From: Sue Howell
Sent: 28 May 2019 15:01
To: Planning.Responses
Cc: Anita Gardner
Subject: RE: Planning Consultation on: FG/29/19/PL

Town & Country Planning Act 1990 (as amended)
Town and Country Planning (Development Management Procedure)
(England) Order 2015
Planning Permission
APPLICATION **FG/29/19/PL**
NO:

Site Address: South Point 1 Beehive Lane Ferring BN12 5NL

Description of Erection of 1 No. 2 bed dwelling
Works:

PLANTING AREA 02

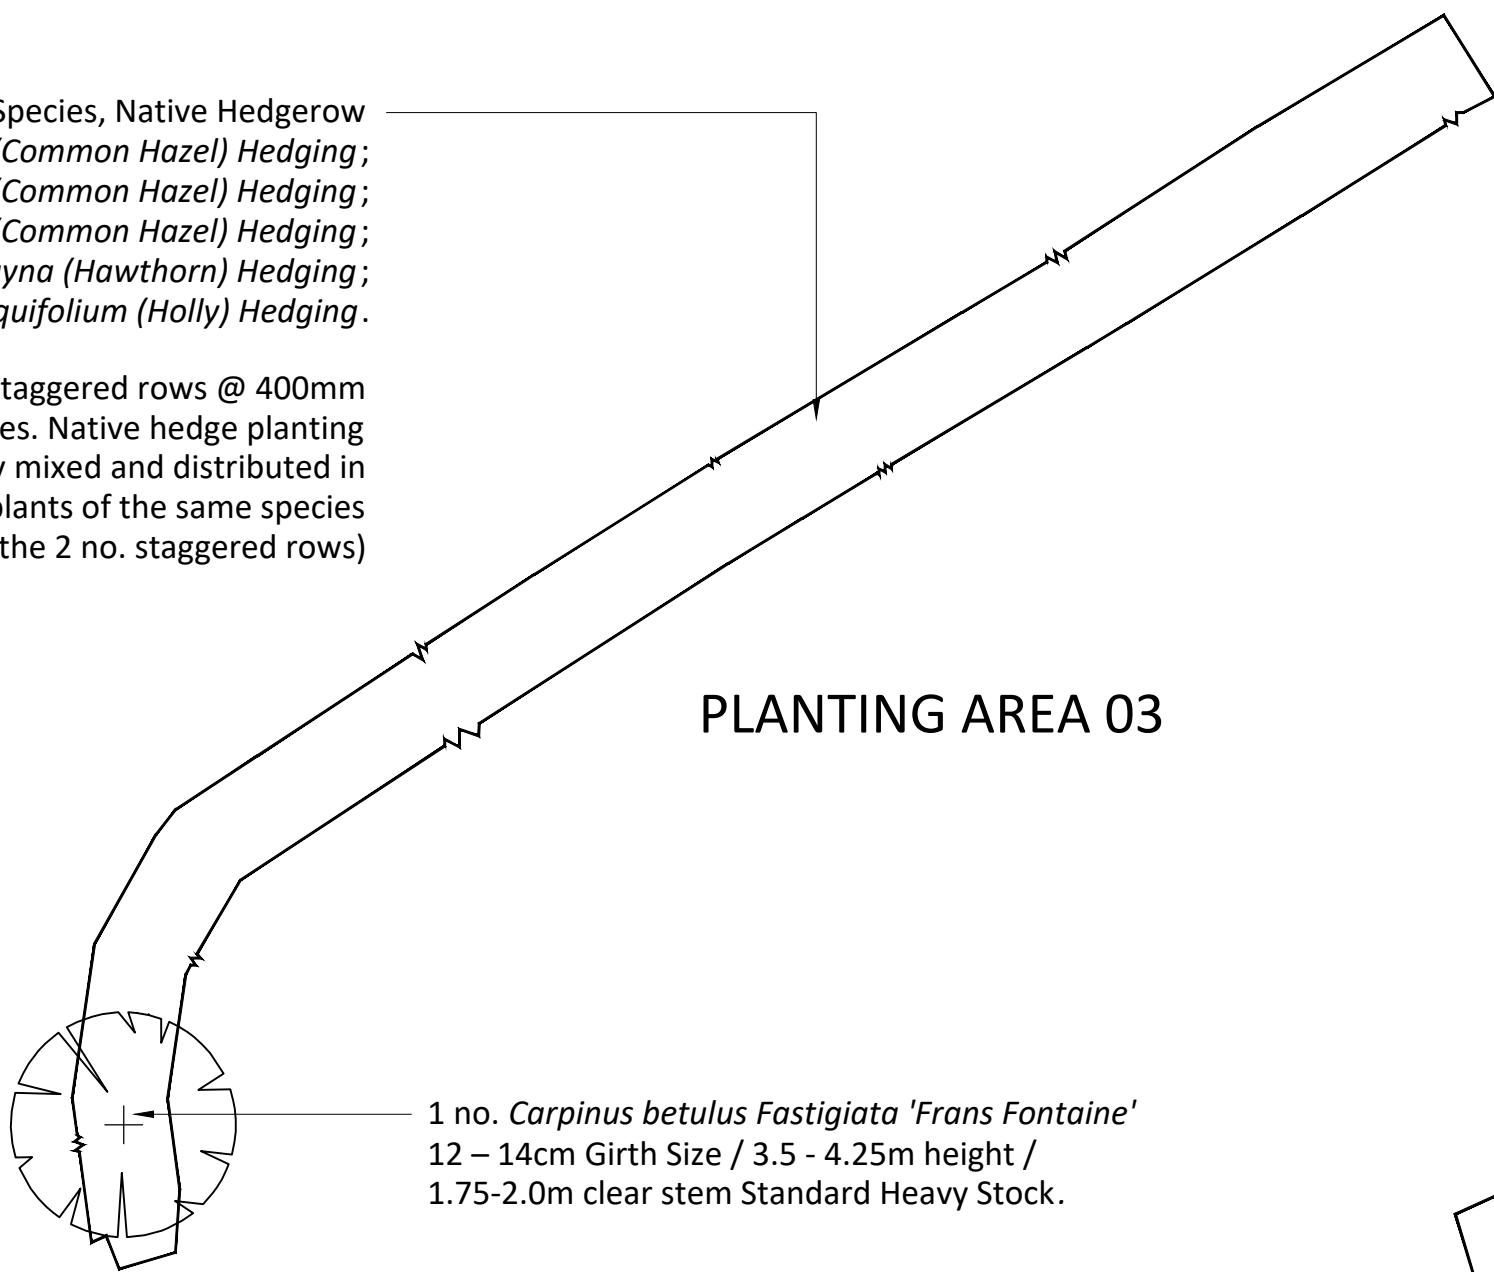
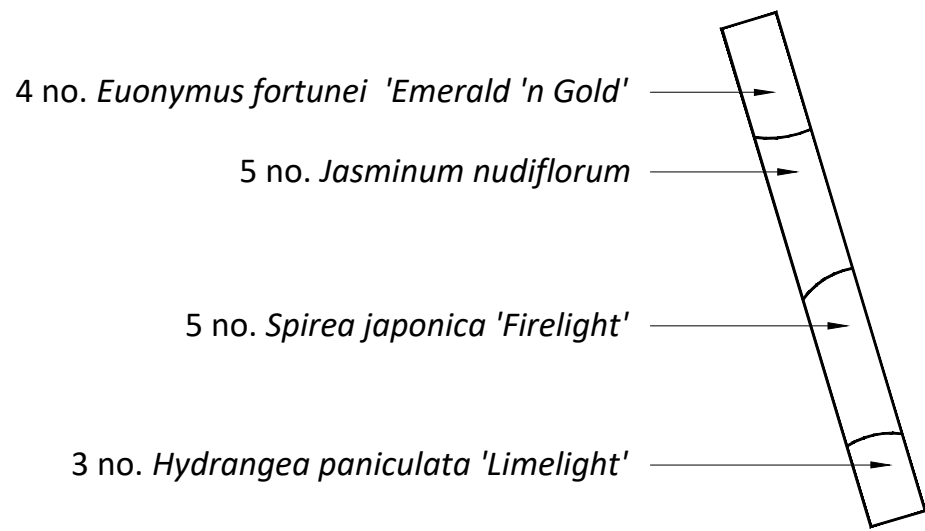
The landscape Detailed Planting Plan RCo 155/02 Rev 04 has provided a scheme which is varied, detailed and proposes a scheme which is appropriate for location. The detail shown has incorporated blocks of planting, specimen plants and trees. The inclusion of specimen shrubs and trees will give a certain degree of instant screening which will assist in blending the proposals into its surrounding, offering some screening and increasing the biodiversity of the site.

The plans have detailed a scheme showing plant species, planting densities and size at time of planting.

My recommendation is that the detail provided is appropriate for location and in sufficient detail. I would recommend no landscape objection, subject to the landscaping being implemented ideally before occupation and no later than the first planting season post completion.
